## Comments on the Applicant's D1 Submissions

This document sets out the comments by Cambridgeshire County Council (**CCC**) and Fenland District Council (**FDC**) (together, **the Councils**) on the Applicant's Deadline 1 (**D1**) submissions. The tables below set out the document in question that the Councils are commenting on, together with the relevant paragraph or reference number.

- Notes:
1. Proposed visibility based on New Bridge Lane being subject to a revised 30mph speed limit.
  2. New street lighting has been provided on an indicative basis (at 30m intervals and at conflict areas) and will require detailed design and assessment.

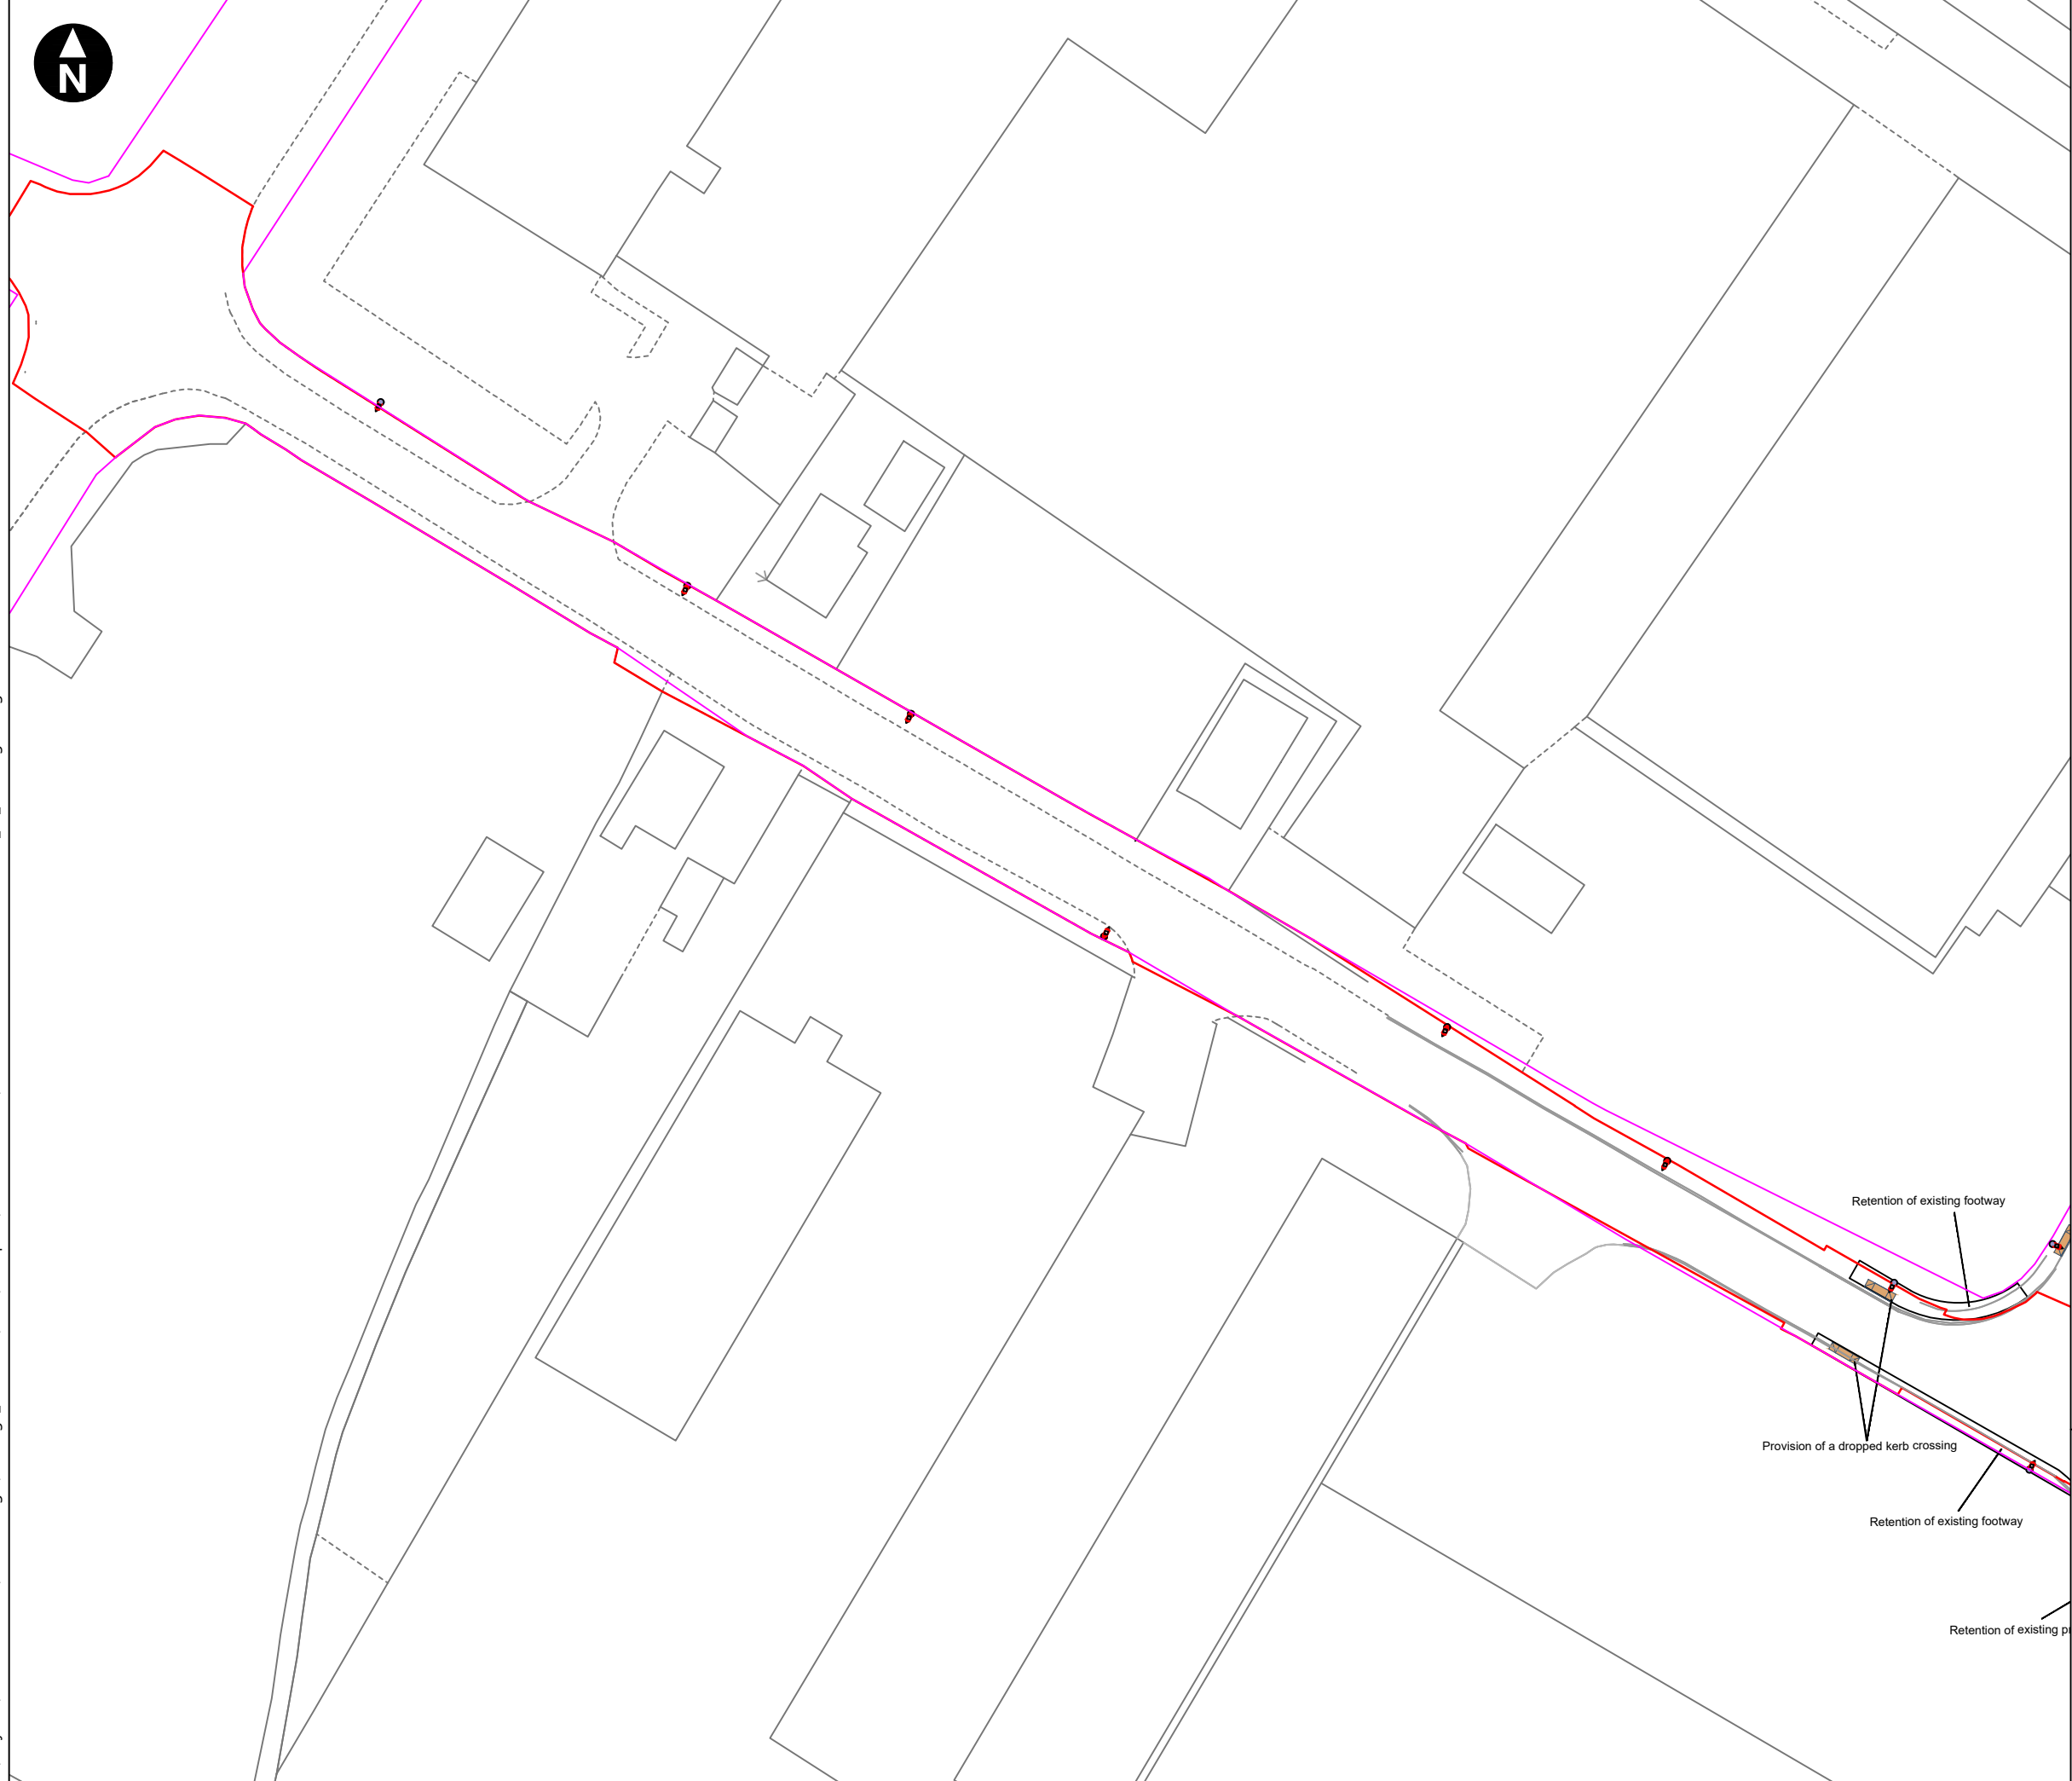
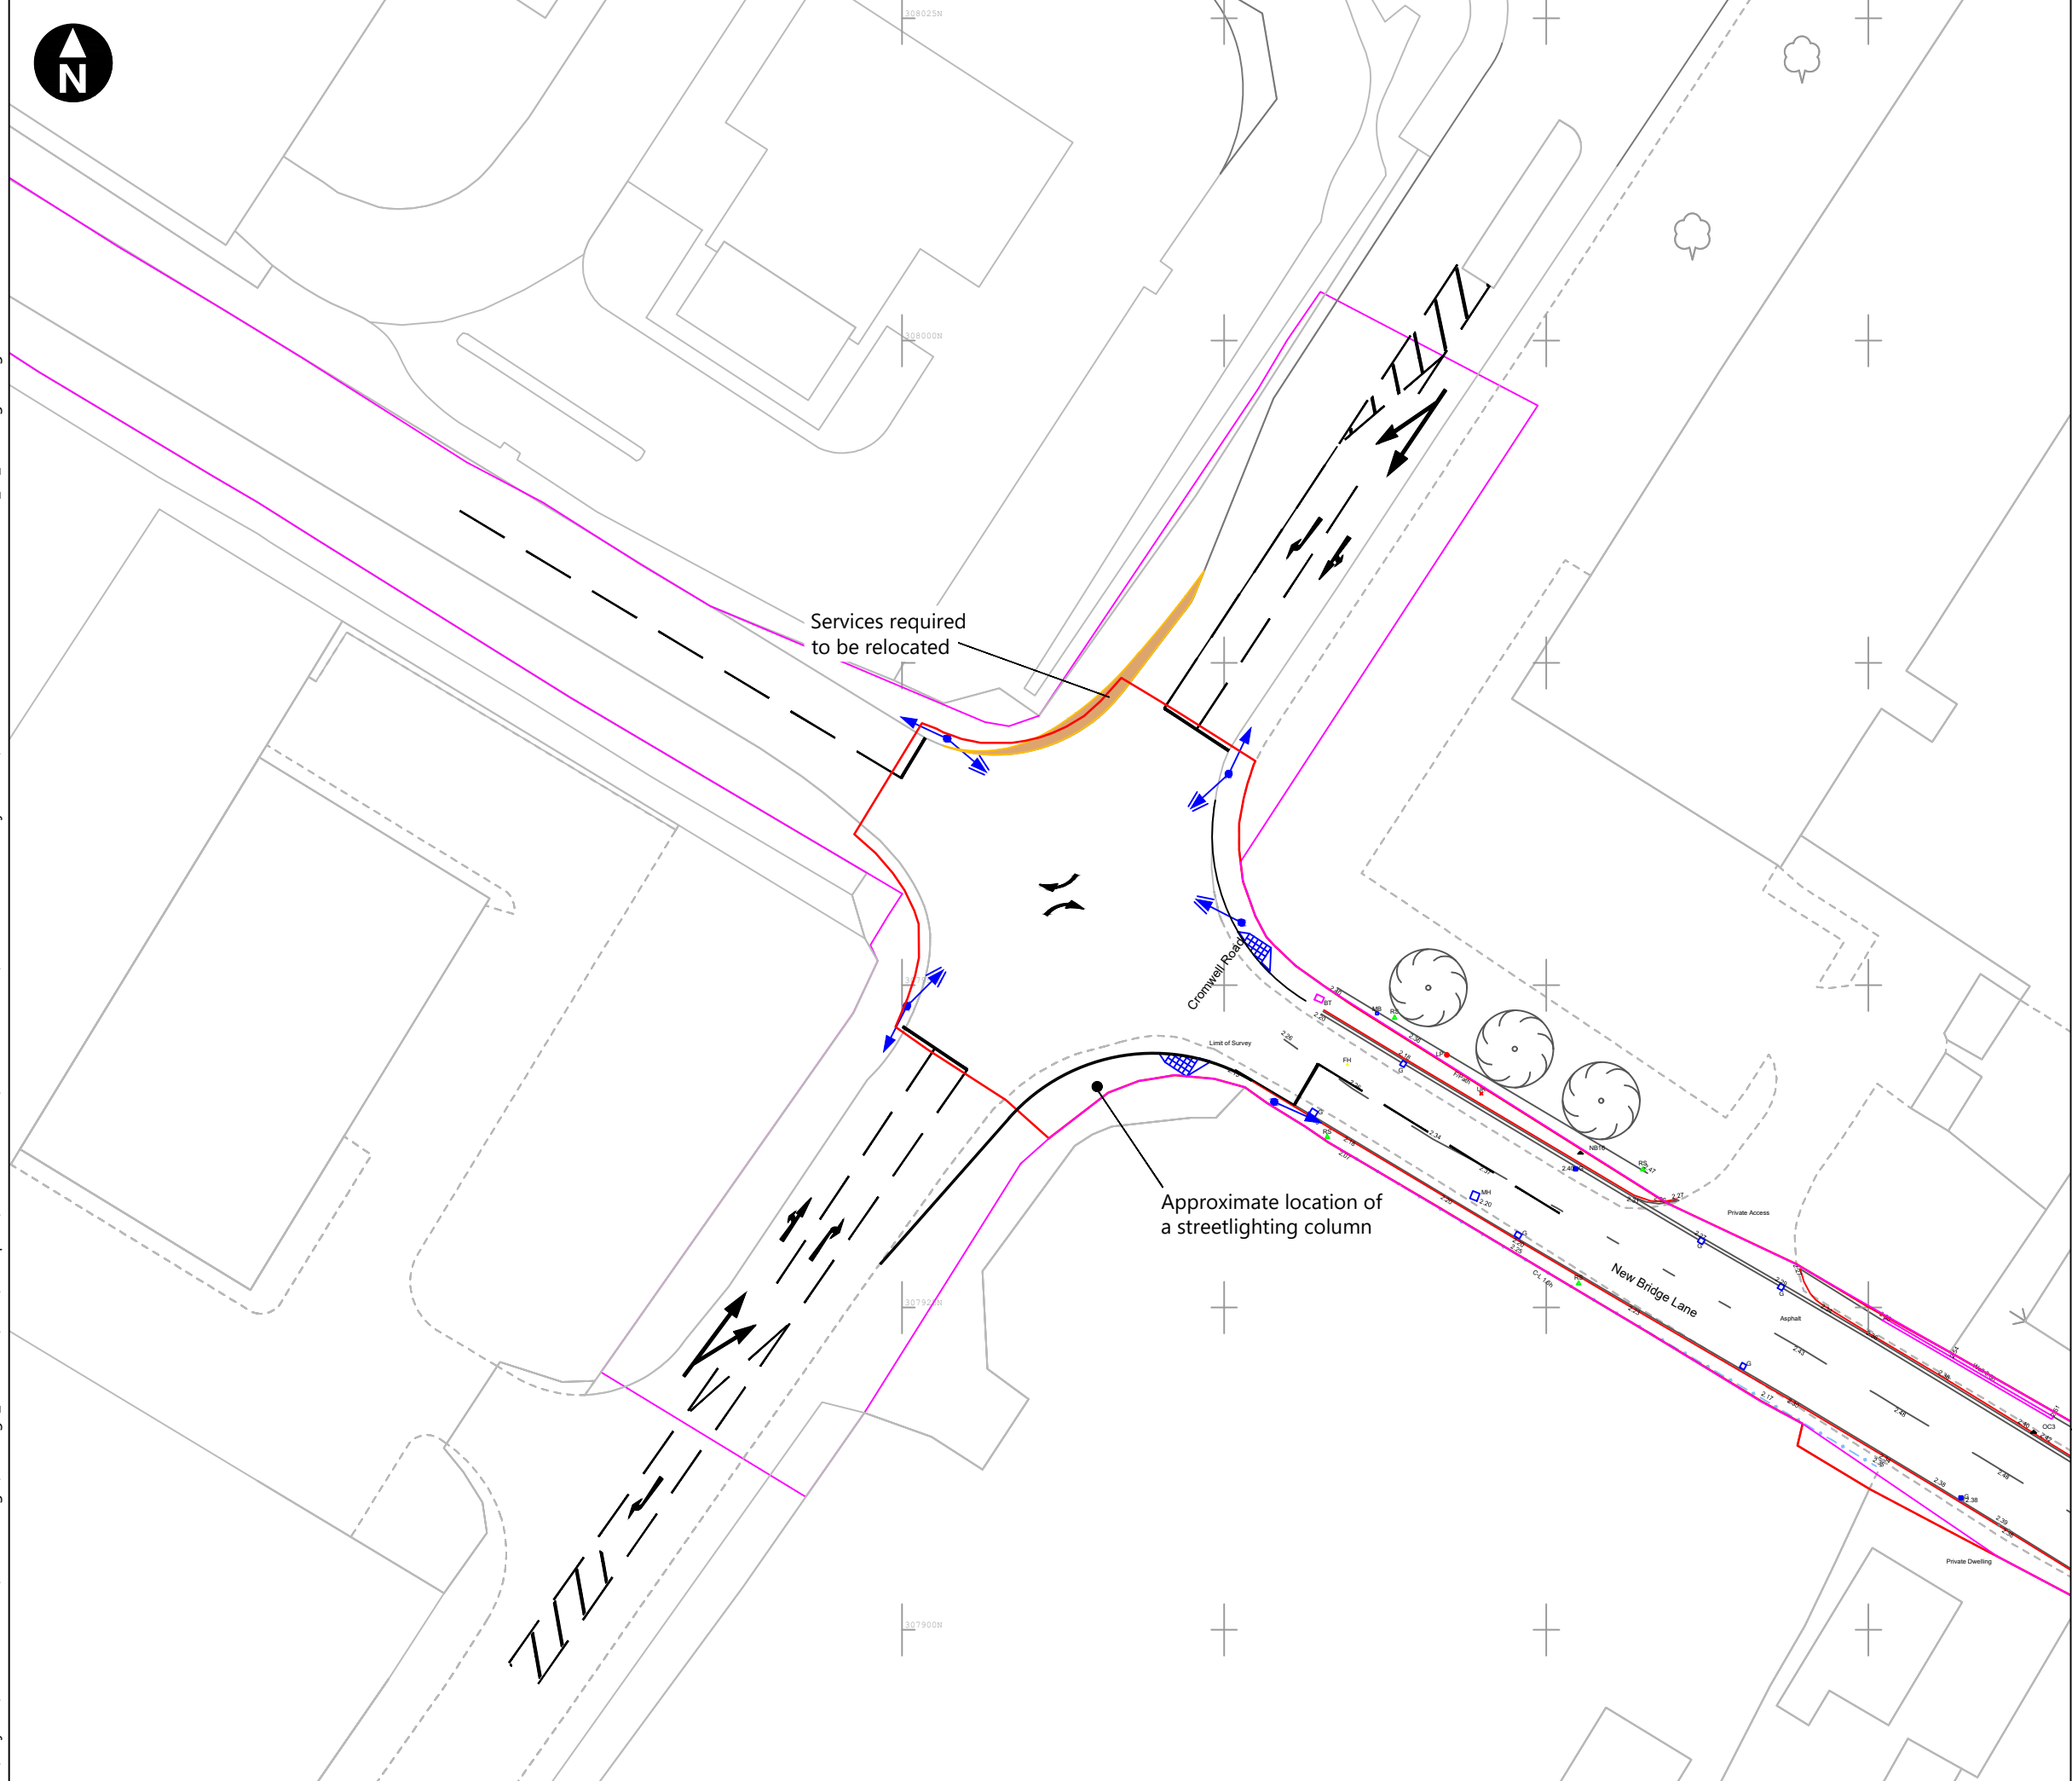
Topic	Paragraph Number	Councils' Comment
Non-motorised users	General	The Outline CTMP does not provide any detail on how access will be preserved for non-motorised traffic that uses New Bridge Lane and the former level crossing as a through route. The Councils request that detail is provided on this.
Damage to highway network	General	<p>The outline CTMP does not address the issue of damage to the wider highway network for which CCC is responsible. It is noted that there is provision for the inspection of access points to the highway to be used by construction vehicles.</p> <p>It is requested that provision be made for “before”, “during” and “after” inspections of the wider highway network to be affected by construction traffic. The methods of these inspections are to be agreed with CCC and the inspections funded by the Applicant.</p> <p>It is further requested that provision be made for the Applicant to fund any highway maintenance works that are required to remedy damage caused by construction traffic to the wider highway network.</p>
